City of Portland, Maine – Building or Use Permit Application 389 Congress Street, 04101, Tel: (207) 874-8703, FAX: 874-8716

Location of Construction: 17 Bartley Ave		Owner: Farrell, Thomas B. & Kathryn W.		Phone: 878-7752		Permit No: 990234
Owner Address: *****SAA 04103		Lessee/Buyer's Name:		Phone:		
Contractor Name: David Dardano		Address: 38 Lynne Ave Ptld, ME		Phone:		Zone: R-2 CBL: 379-H-003 Zoning Approval: <i>ok with conditions</i> Special Zone or Reviews: <input type="checkbox"/> Shoreland <i>→ 3/19/99</i> <input type="checkbox"/> Wetland <input type="checkbox"/> Flood Zone <input type="checkbox"/> Subdivision <input type="checkbox"/> Site Plan maj <input type="checkbox"/> minor <input type="checkbox"/> mm <input type="checkbox"/> <i>14, 586</i> Zoning Appeal <input type="checkbox"/> Variance <input type="checkbox"/> Miscellaneous <input type="checkbox"/> Conditional Use <input type="checkbox"/> Interpretation <input type="checkbox"/> Approved <input type="checkbox"/> Denied Historic Preservation <input checked="" type="checkbox"/> Not in District or Landmark <input type="checkbox"/> Does Not Require Review <input type="checkbox"/> Requires Review Action: <input type="chec

FIRST FLOOR PLAN
SCALE: 1/4" = 1'-0"

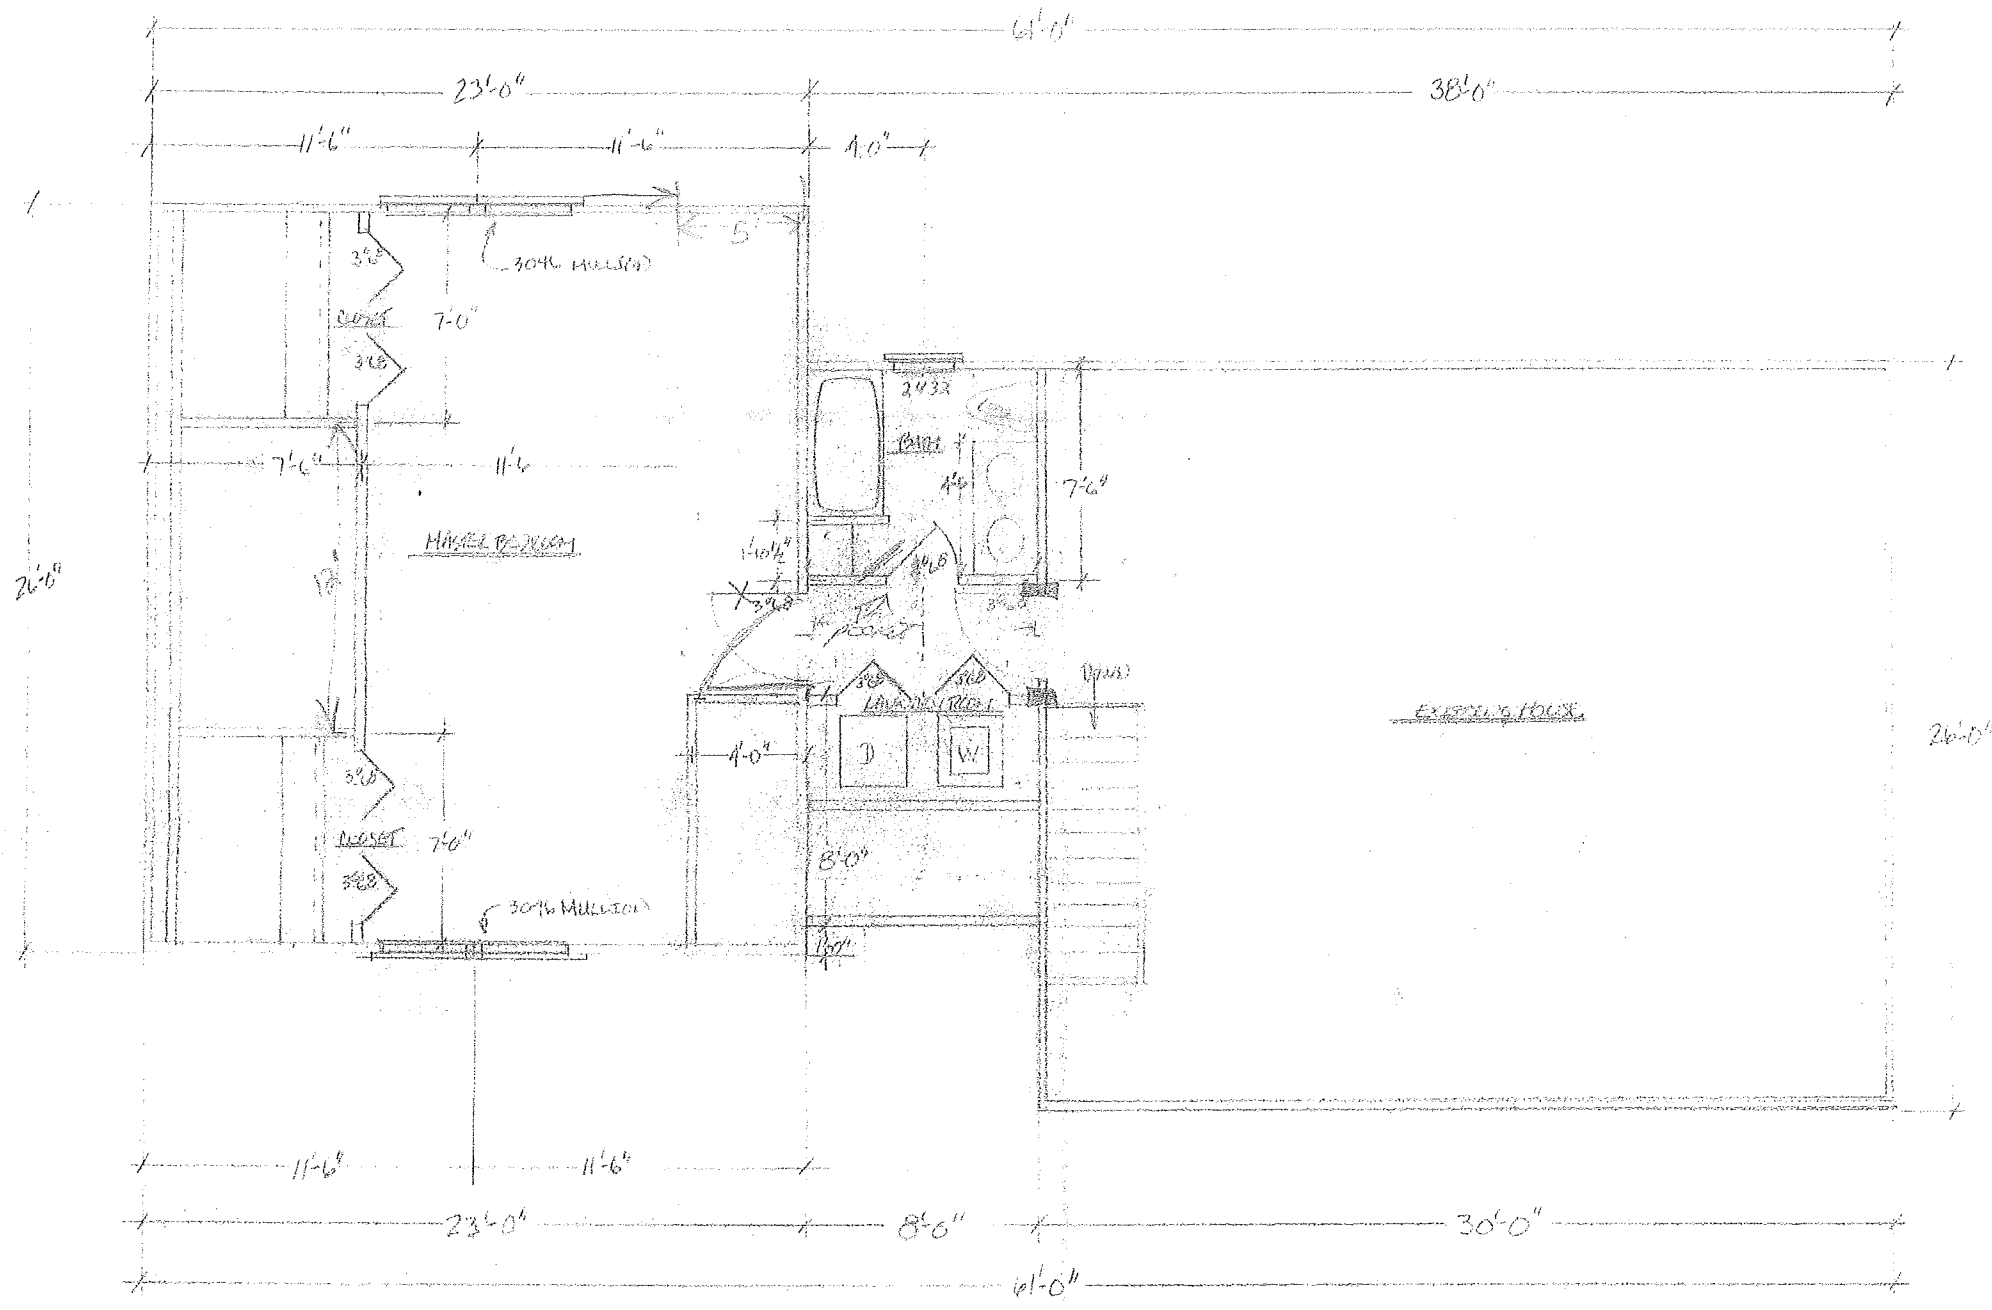
33. Glass and glazing shall meet the requirements of Chapter 24 of the building code.
- X-34. *Your application plan shows a steel beam being used in garage but there was not a detail on its design or how it was to get the one (1) hour fire rating required under the code - Please submit this information before work is started - Call me if you have any questions.*
